## Objection to Stage 1 DA for SSD 7874

### Redevelopment of the Harbourside Shopping Centre

Prepared on behalf of the Owners of Strata Plan 49249

Analysis of Visual Effects and Impacts on One Darling Harbour

SECTION ENVELOPE Section 1
1:500

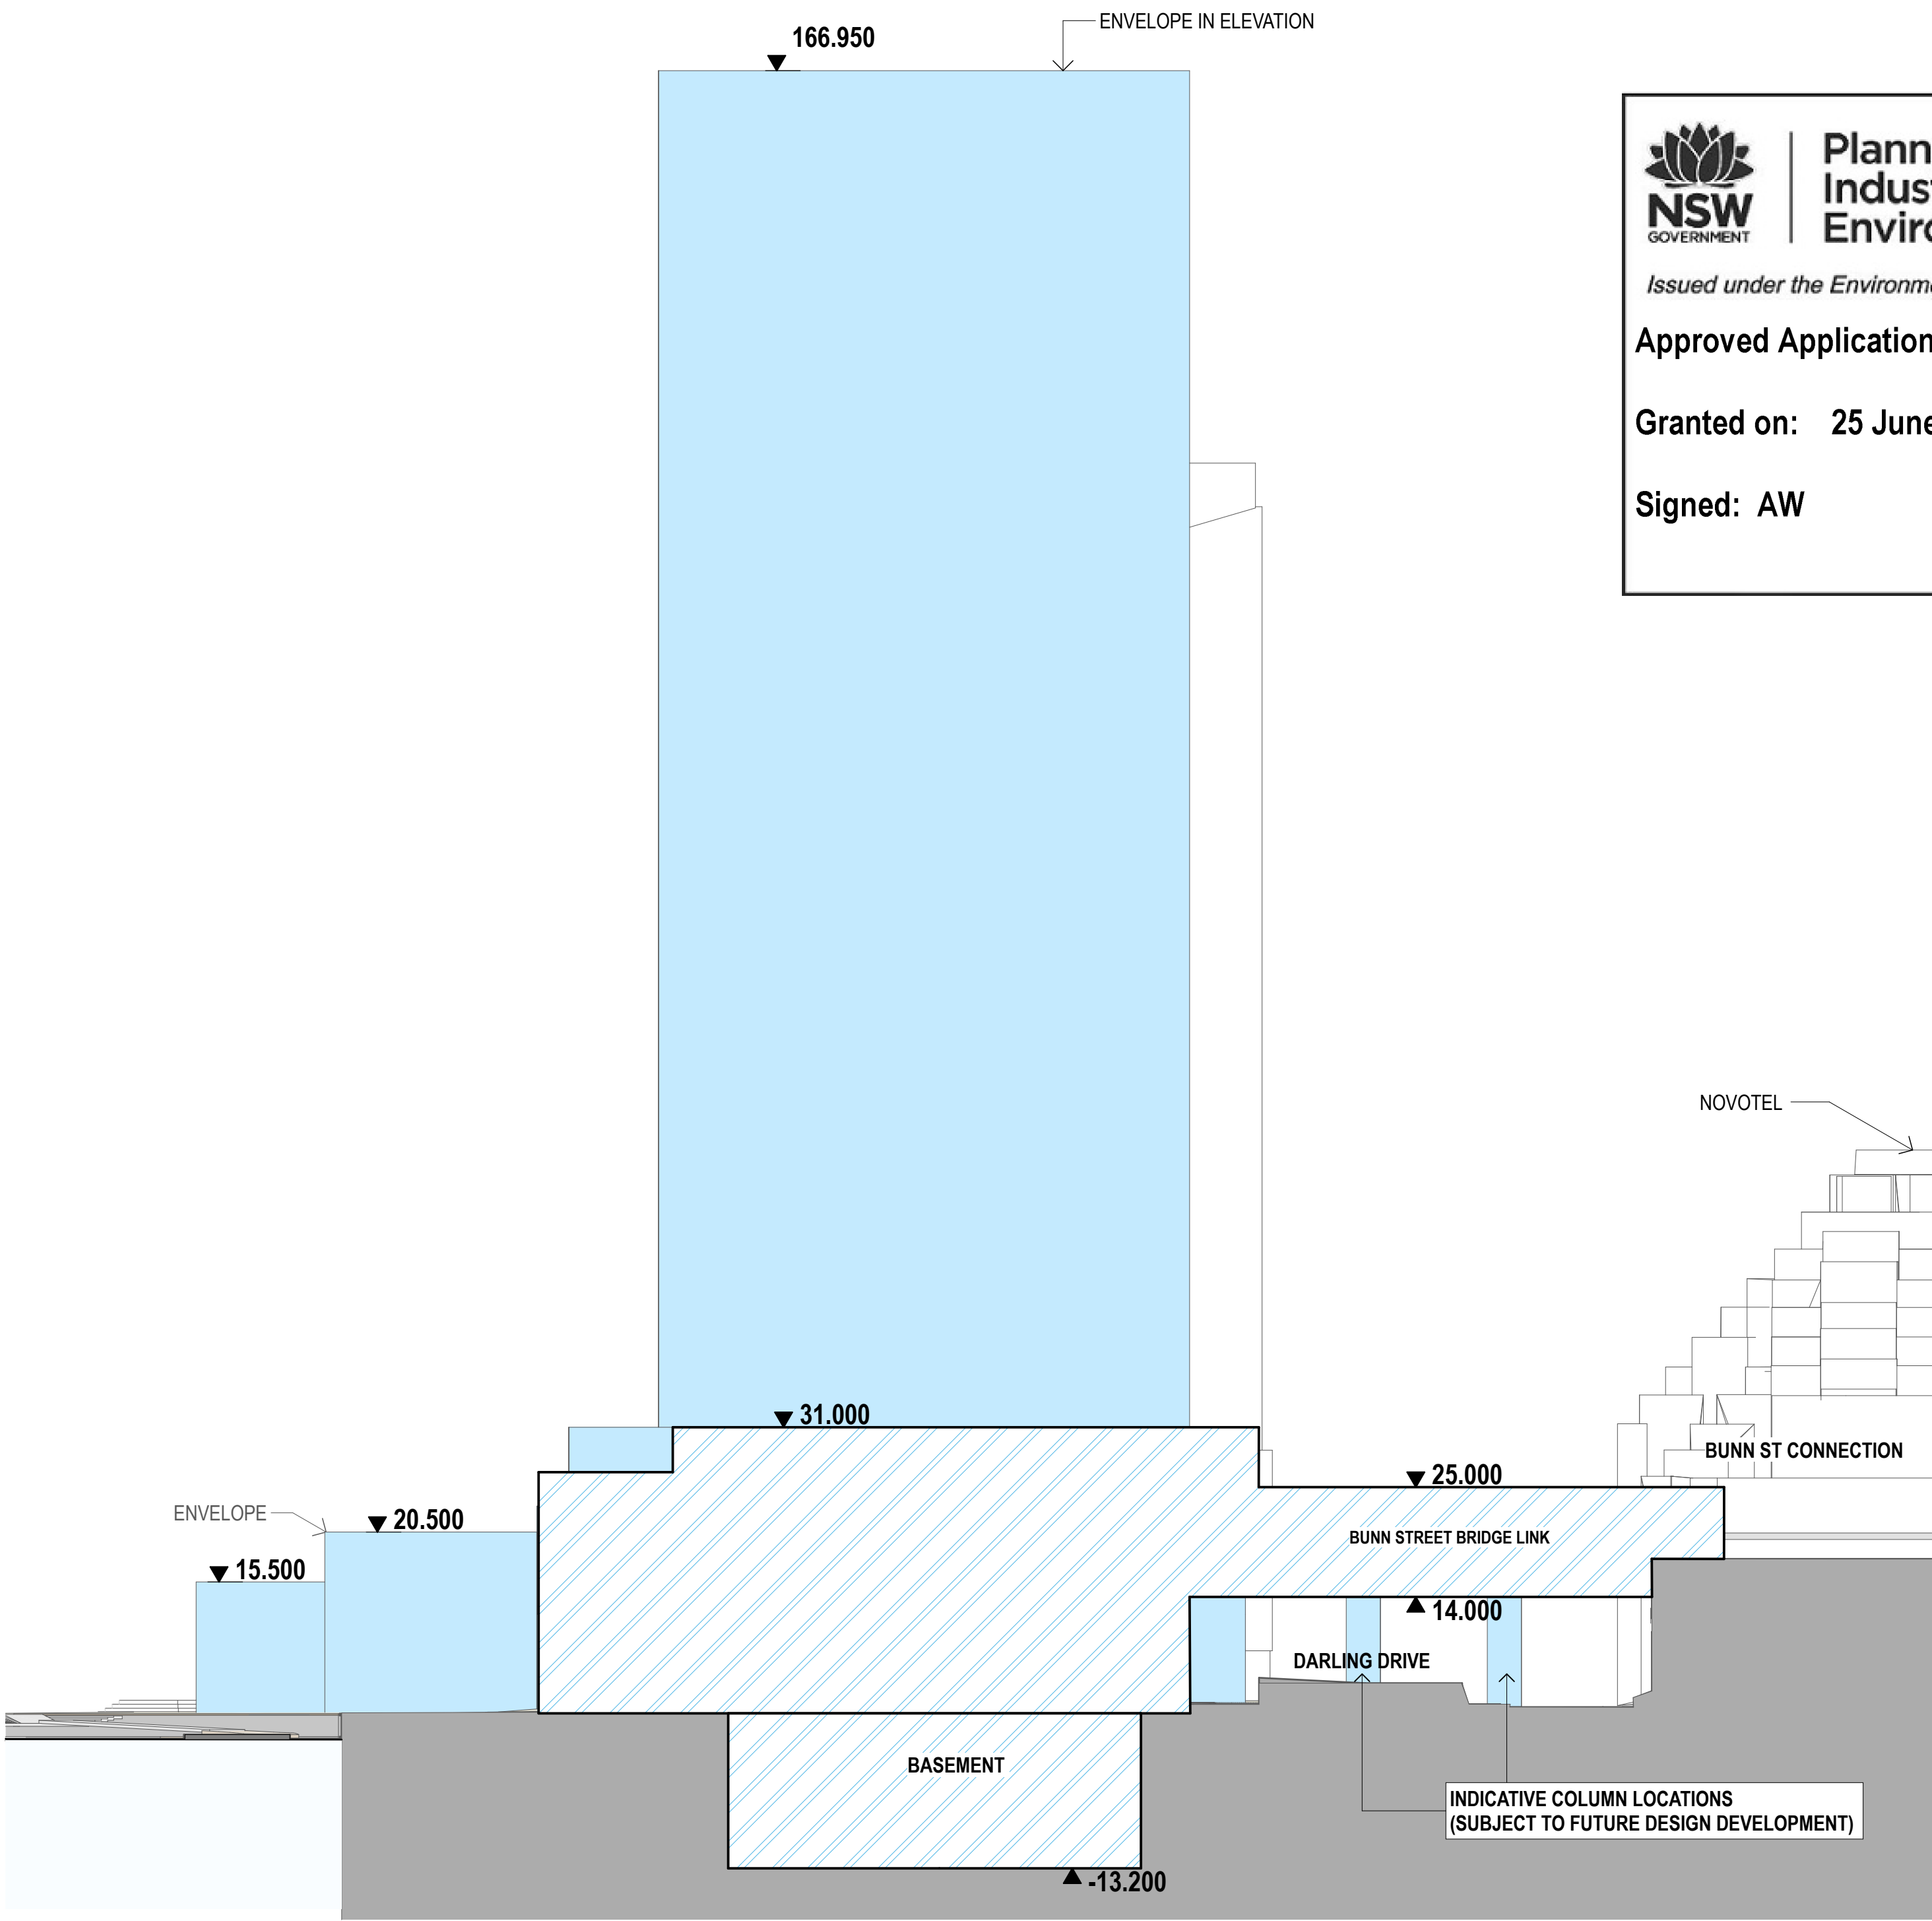
The proposed podium envelope includes a number of steps in height. The predominant heights ie. those that apply to the majority of the podium closest to One Darling Harbour, are at RL 25.50 south of the tower form and RL 30.50 and RL 23.80 immediately north of the tower form. The podium reduces in height towards the Pyrmont Bridge in series of narrow sections the predominant height of which is RL 17.50. Whilst this may provide a visual transition and a change to the interface with the heritage item, it does not provide a significant or appropriate opening up of views.

The height of the podium envelope increases via a stepped transition to the taller tower form eg. RL 25.5, RL 30.0 before rising significantly in height to RL 41.9 and RL 54.5. We note that the angled section of envelope at RL 54.50 is not considered in the applicant's documentation to form part of podium, notwithstanding it extends 21.52m to the south of the tower and will increase the potential view blocking for apartments located at the south end of the One Darling Harbour.
